**Representation in respect of an Application by Orsted Hornsea  
Project Three (UK) Ltd for an Order Granting Development Consent  
for the Hornsea Project Three Offshore Wind Farm.**

**Response by Kelling Estate LLP**

**Planning Inspectorate Reference: EN010080**

Date: November 2018.

Figure 3.11: Weybourne to High Kelling.

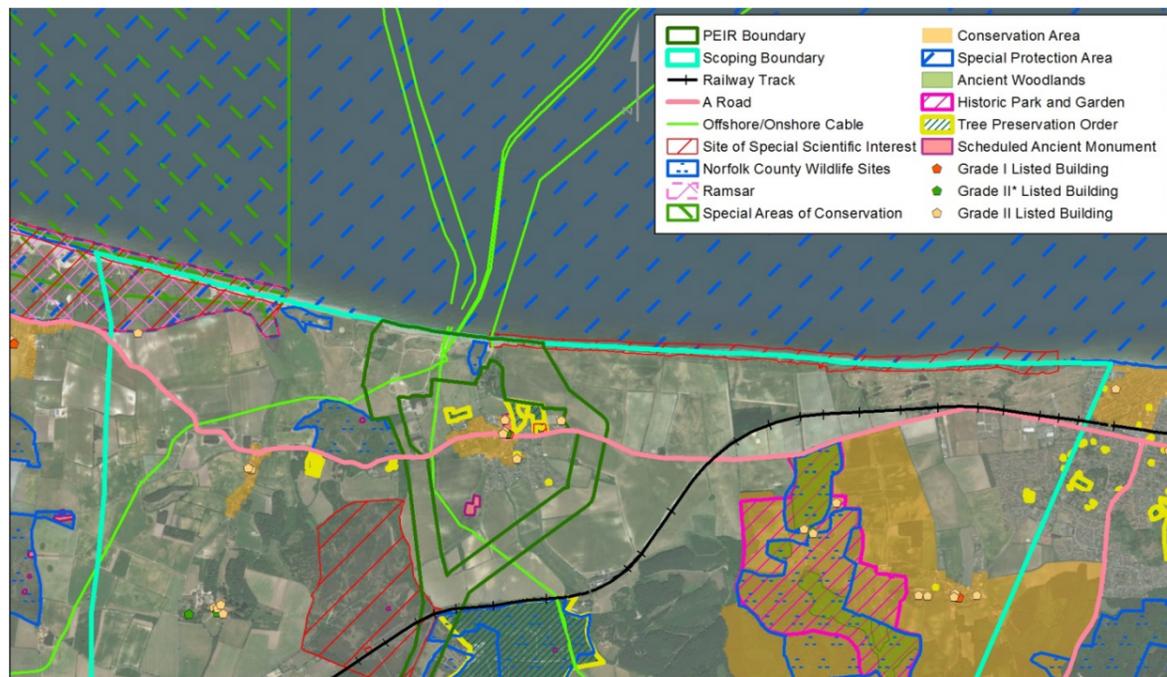
- 2.6 The chosen route is an alternative that was proposed at a late stage of the initial consultations. We understand that the current route was chosen to avoid difficulties crossing the North Norfolk Railway.

- 2.7 We are not aware that the potential difficulties in crossing the North Norfolk Railway were ever investigated beyond the point of first survey. Requests were made to see the technical and engineering reasoning for why the first proposed route had to be abandoned and the current route adopted.

- 2.8 Our clients wish to understand the sound technical and engineering reasons for why the route was altered to cross their property and increase in length by approximately 1.1km. No information of substance has been provided to date.
-

- 3.1 It is our client's belief that the Orsted proposals fail to consider the impact on the Natural Capital and business interests of Kelling Estate LLP. It will significantly impact on the Estate's ability to deliver a product that it has spent years developing. We believe that the cable route could follow a shorter and more direct route from landfall to Warren Farm and
-

to date have not been provided with evidence as to why this shorter route was not possible, as opposed to not desirable, to take.
